Your Ref: 2023/91032
Our Ref: Z001960

26th April 2023

12 Highroyd, Lepton, Huddersfield – Demolition of existing conservatory and erection of single and two storey side and rear extension

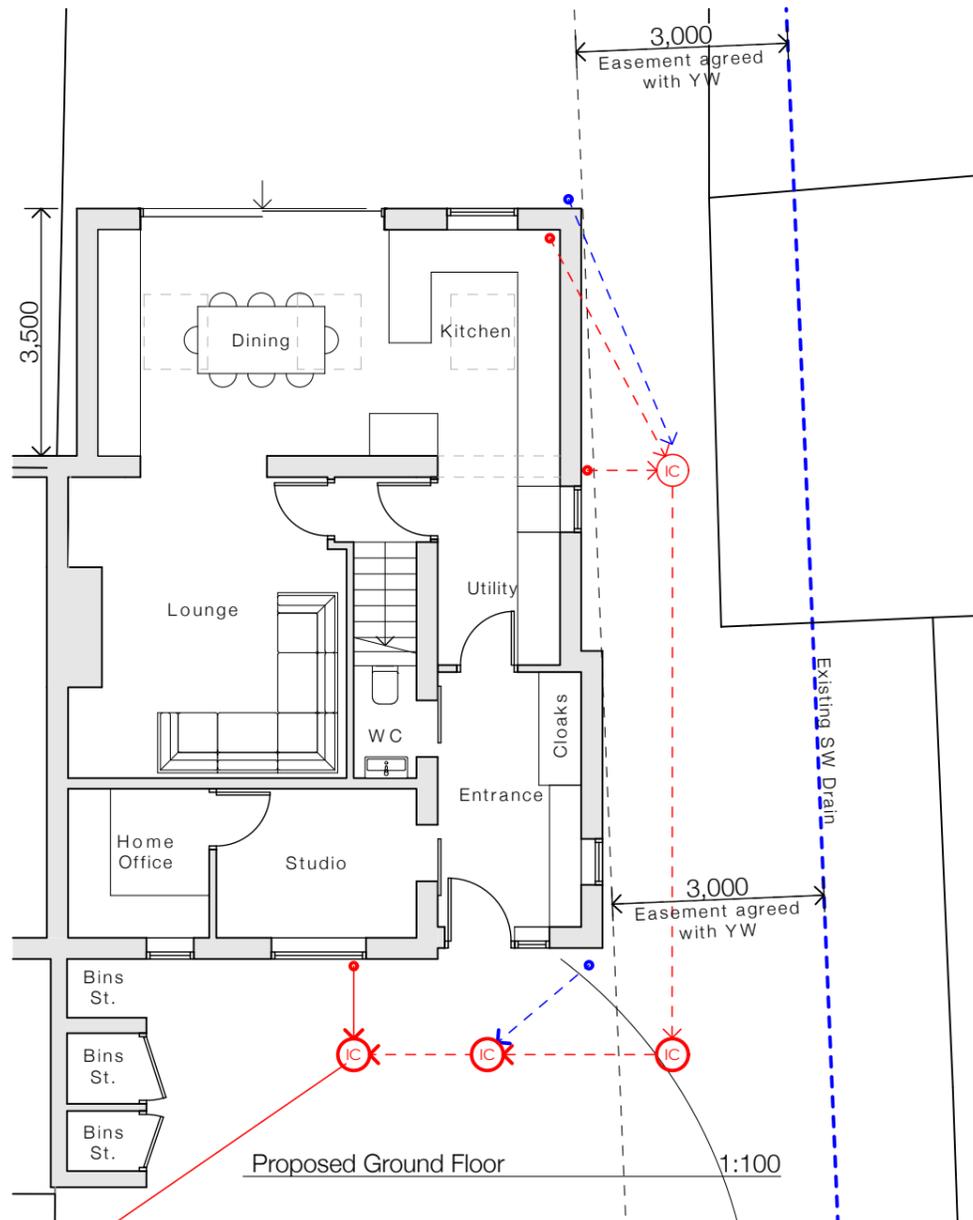
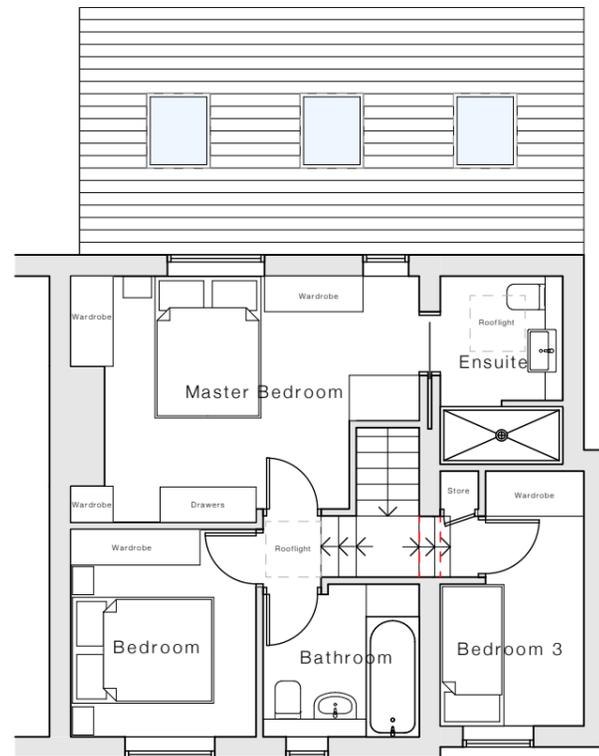
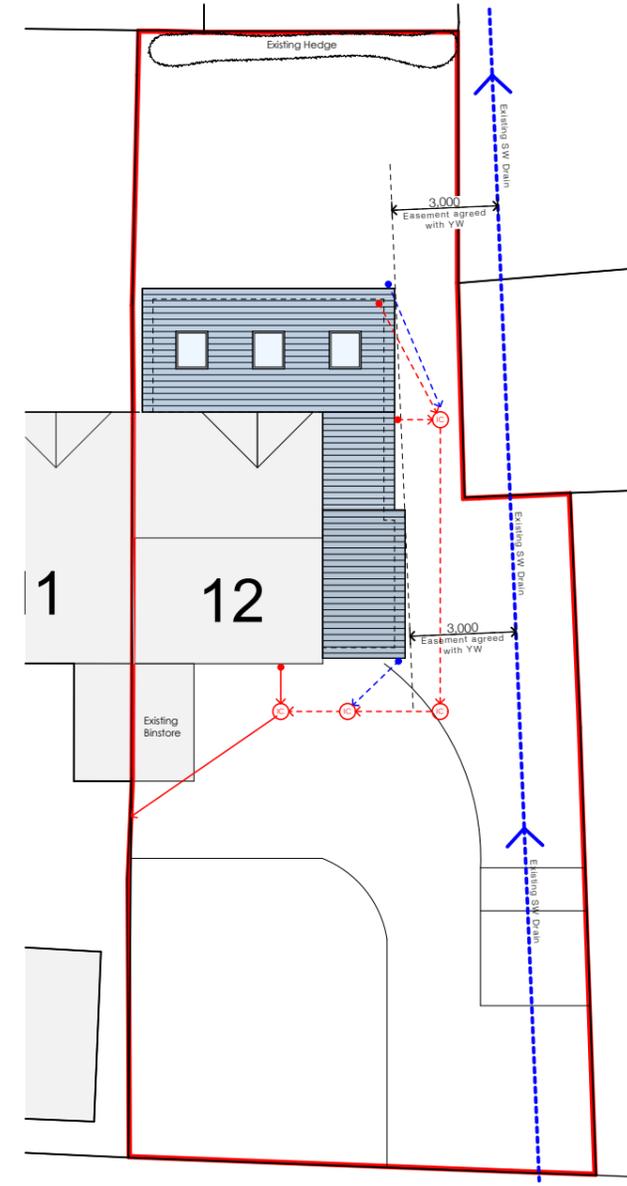
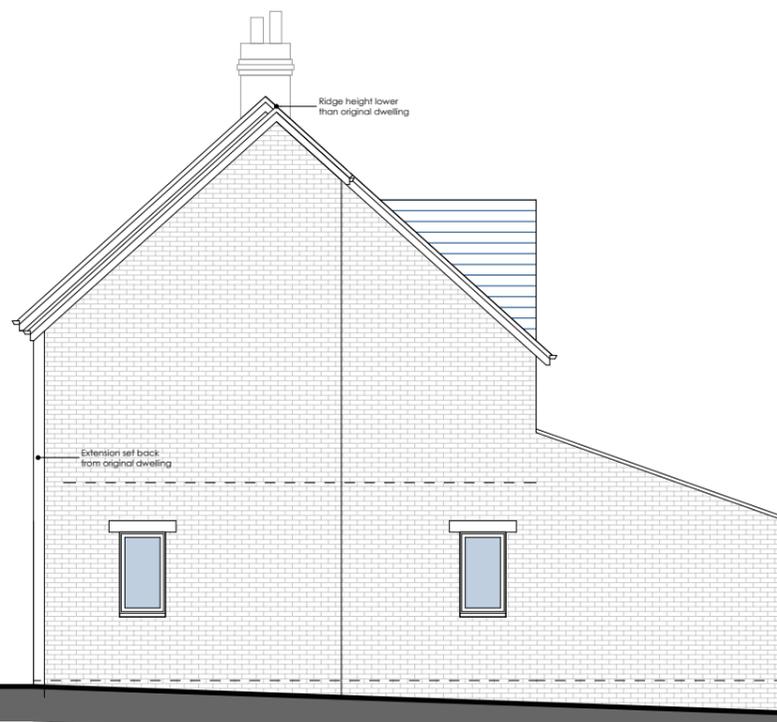
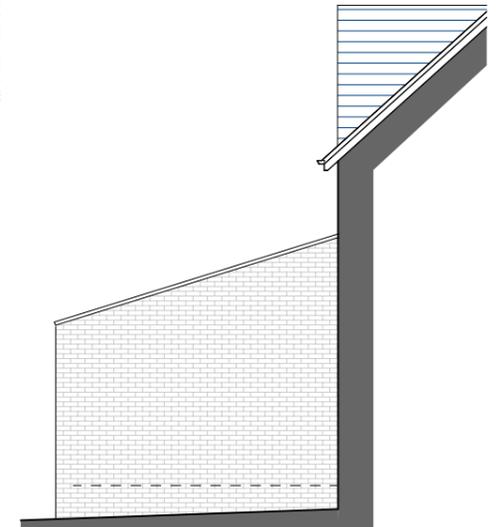
- 1.) Yorkshire Water has no objection in principle to the drainage details submitted on drawing 'Proposed Plans and Elevations' (rev B) 0110/2017-05 dated October 22, namely: -
 - a.) The proposed building stand-off from public sewer centre-line (of three metres)
 - b.) Foul and surface water discharging into existing drainage system.

- 2.) On the Statutory Sewer Map, there is a 450 mm diameter public surface water sewer recorded to cross the site. It is essential that the presence of this infrastructure is taken into account in the design of the scheme.
 - a.) It may not be acceptable to raise or lower ground levels over the sewer and we will not accept any inspection chambers on the sewer to be built over.

b.) In this instance, a stand-off distance of 3 (three) metres is required at each side of the sewer centre-line and it may not be acceptable to raise or lower ground levels over the sewer, nor to restrict access to the manholes on the sewer.
